Planning & Urban Development Department

October 28, 2014

RE: 72 Westminister Avenue – 181 B002 – R-3 Residential Zone – Disability Variance – Permit #2014-02495

C1 SITE PLAN

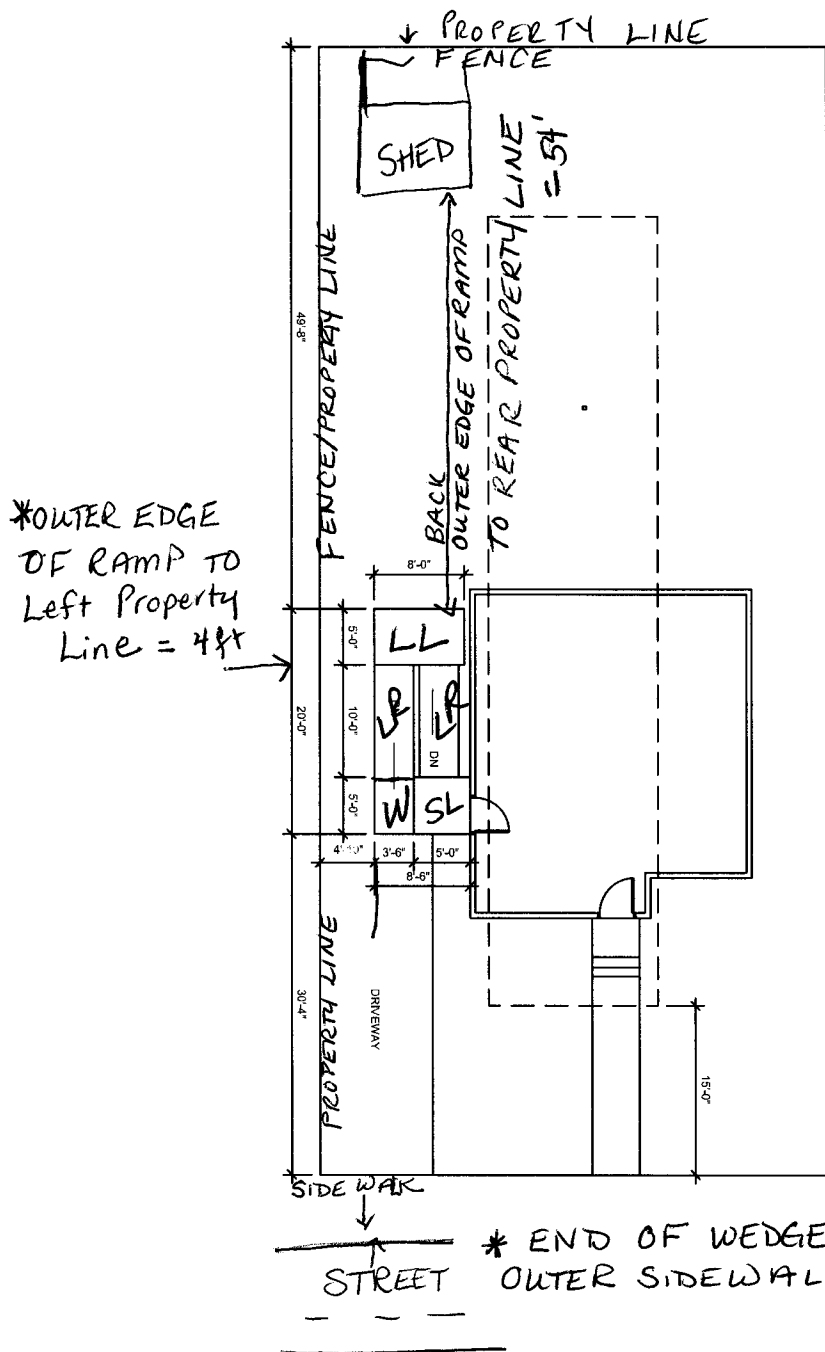
Custom Float Services has applied for a permit (#2014-02495) to install a temporary ADA Critical Access ramp for you at your property at 72 Westminister Avenue. This property is located in the R-3 residential zone. The required side yard setback is eight (8) feet [section 14-90(d)(3)]. The site plan that was submitted shows the side yard setback from the ramp as four feet. The proposed ramp does not meet the side setback requirement, so you will need to apply for a Disability Variance. Since the ramp has to be installed immediately, I have signed off on the permit, and it has been issued. You will need to apply for a Disability Variance within thirty days of October 28, 2014.
